EAST PRESTON PARISH COUNCIL

16th July 2009

Re: EP/90/09, Churchfield, Station Road, East Preston

At its meeting on Monday, 13th July, the Planning Committee of this Parish Council agreed to object to this Application on the following grounds –

Section Profile - Plots 1 - 5

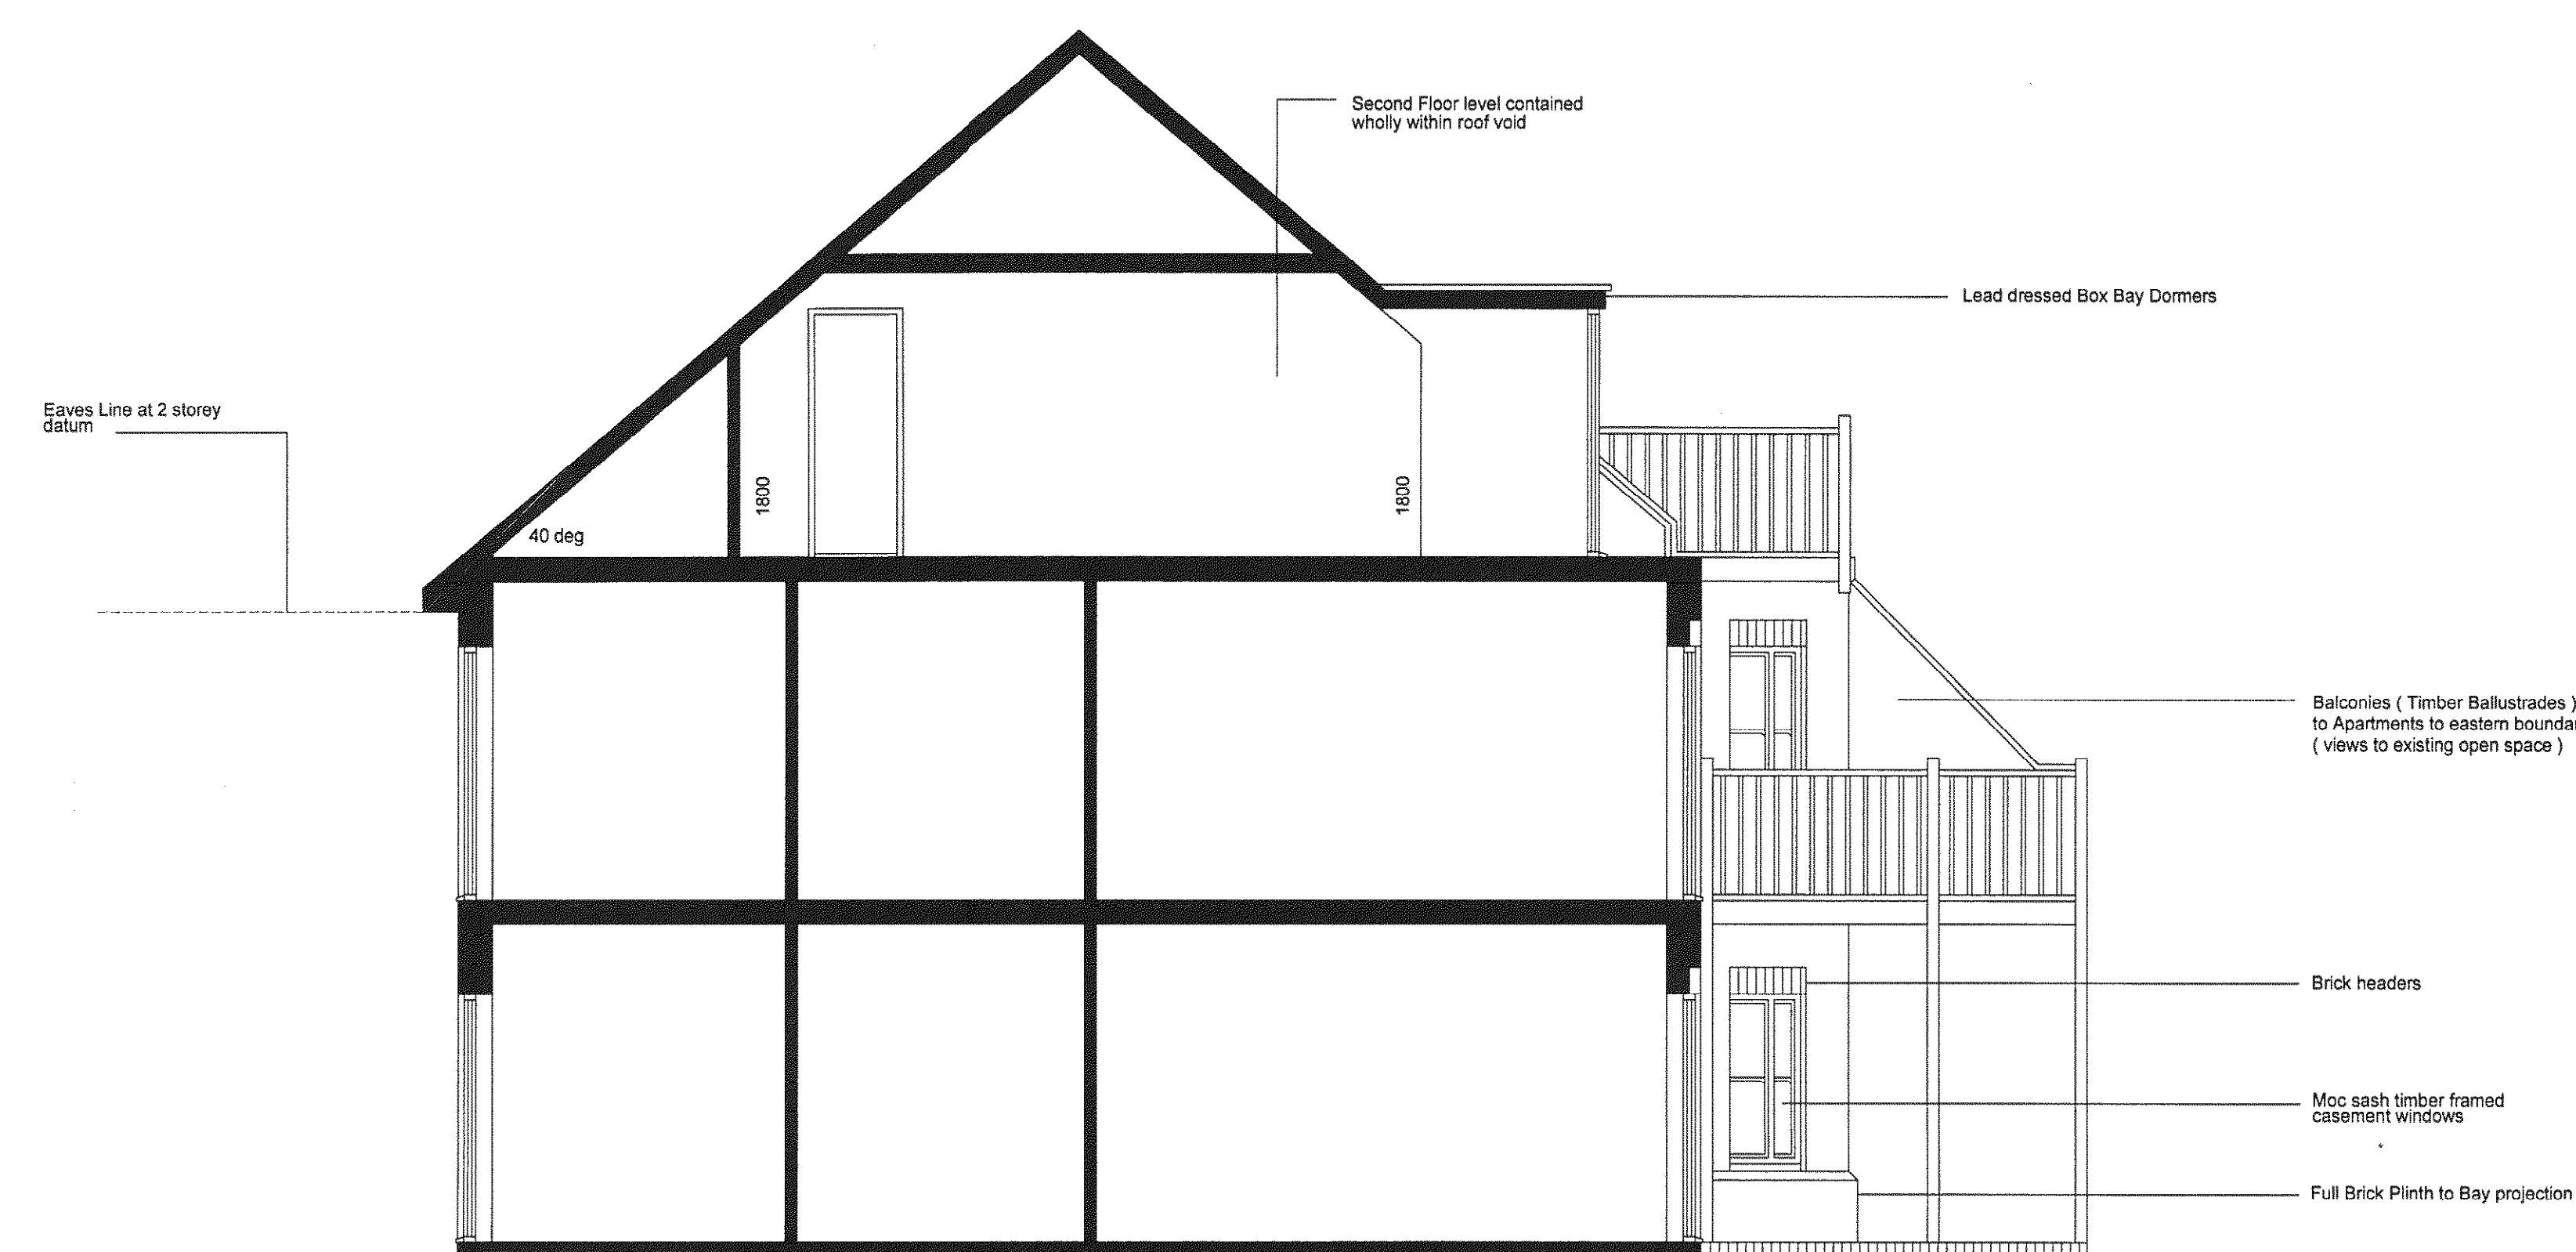
2. The proposed building of a terrace of 2½-storey modern terraced houses and the end of a block of 2½-storey flats, both brick and tile hung rendering, close to the boundary of the church conflicts with policies GEN 7 and DEV 11 of the Local Plan. The urban style buildings do not respond positively to the characteristics of the site and does not respect and enhance the special qualities of the 12th Century Grade 1 Listed Church. Although the proposed tree planting will partially screen the buildings, if the trees were removed the setting of the Listed Building would be damaged by the inappropriate development.
